**TAFE NSW Institute of Applied Technology for Construction (SSD-8571481)
Request for additional information**

I refer to the State significant development (SSD) application and Response to Submissions (RtS) for the TAFE NSW Institute of Applied Technology for Construction (SSD-8571481).

DWG. TITLE
Landscape Plan 2 - Upper Ground

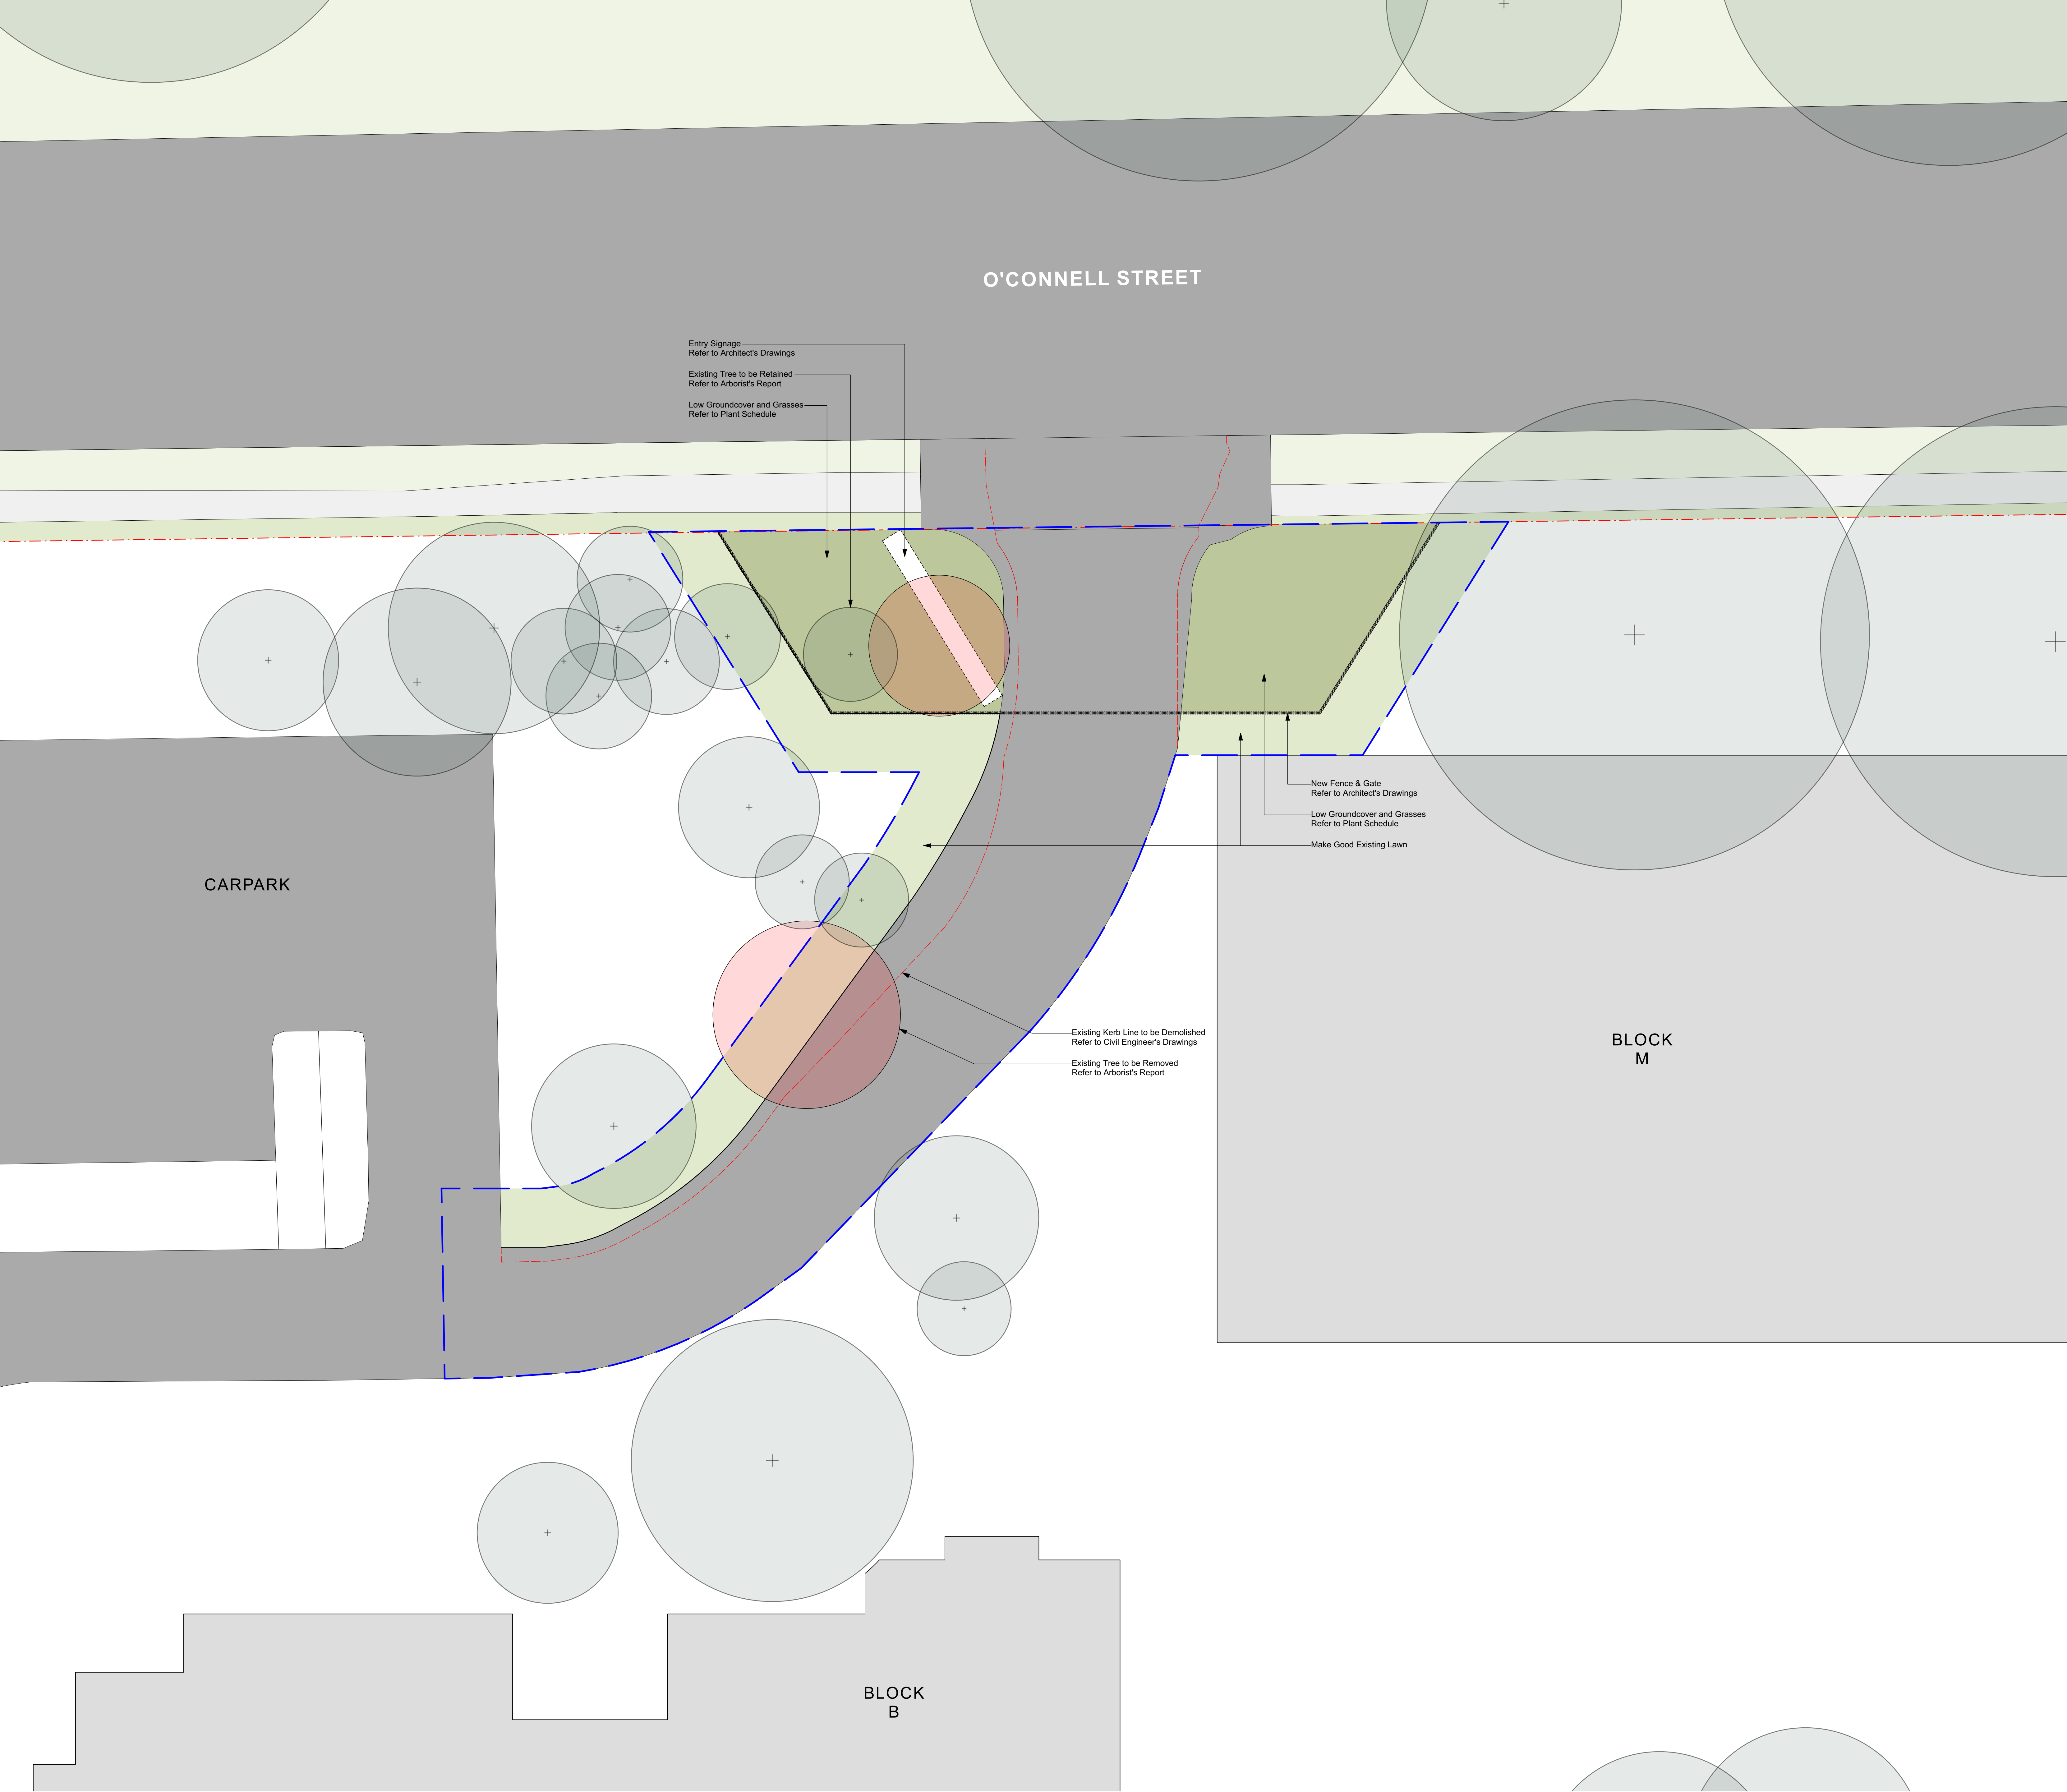
- d) clarify labelling on the landscaping plans submitted with the RtS, which refer to other drawings which do not appear to have been submitted. For example, 'Landscape Plan 1 – Lower Ground' refers to another drawing titled 'L-DA-06', which has not been provided.

- e) ensure that all plans include drawing numbers, including the submitted landscaping plans.
